June 21, 2019

RE: *Hale Sand Pit*
PCD File No. AL1829, PPR 1914
Site Development Plan and Special Use Permit Resubmittals

Thank you for the comments on May 30, 2019 and June 3, 2019 for the above-mentioned project. In an effort to address your comments concisely and simplify your review of the Hale Sand Pit, we have summarized your comments and our responses below.

**EXHIBIT C - PRE MINING PLAN MAP**  
03/25/2019

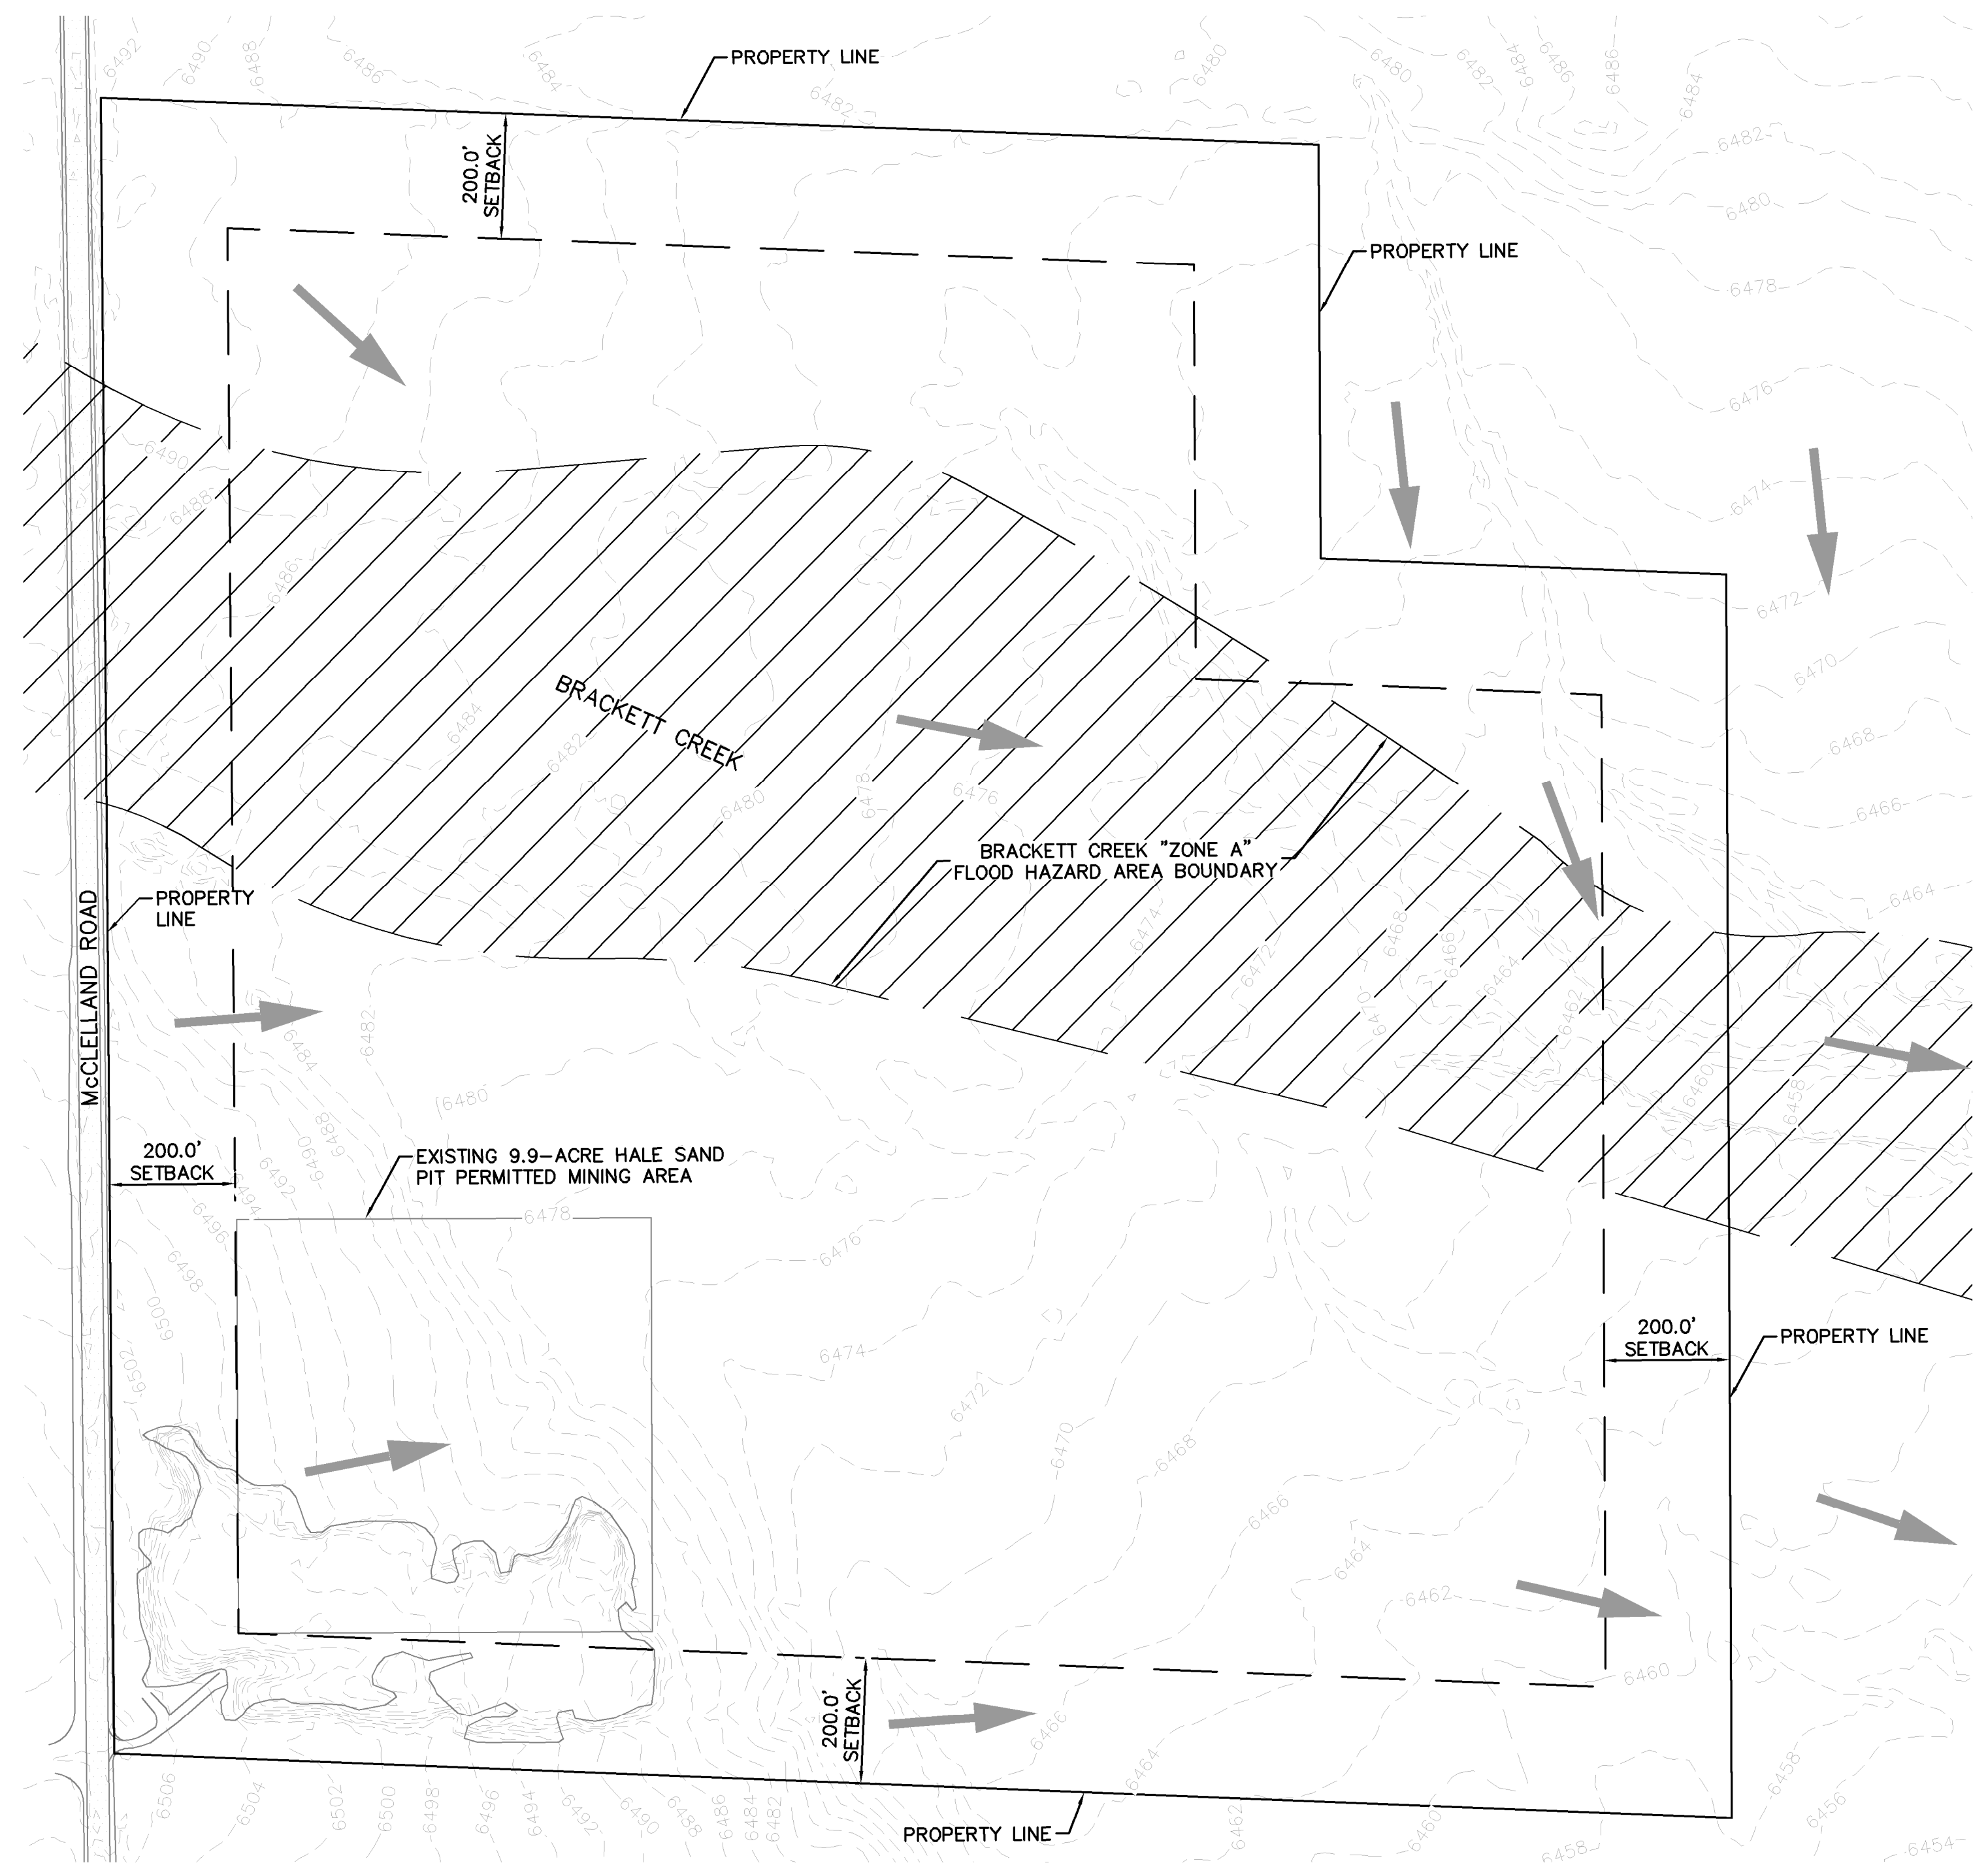
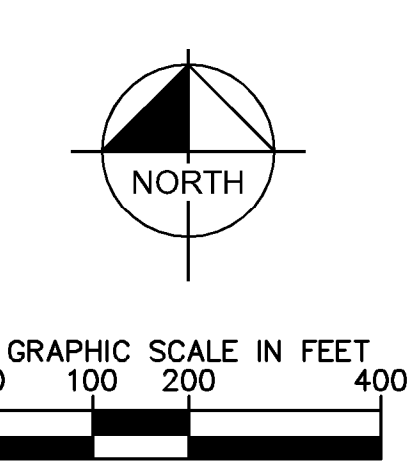
1. (Exhibit C, Pre-Mining Plan Map) Please update the FEMA Firm panel number.
 - *Response: The FEMA Firm panel number was updated.*
2. (Exhibit C, Mining Plan Map) Please update the FEMA Firm panel number.
 - *Response: The FEMA Firm panel number was updated.*
3. (Exhibit C, Mining Plan Map) Flow arrow does not appear correct based on the proposed contours.
 - *Response: The flow arrow was updated to match the proposed contours.*
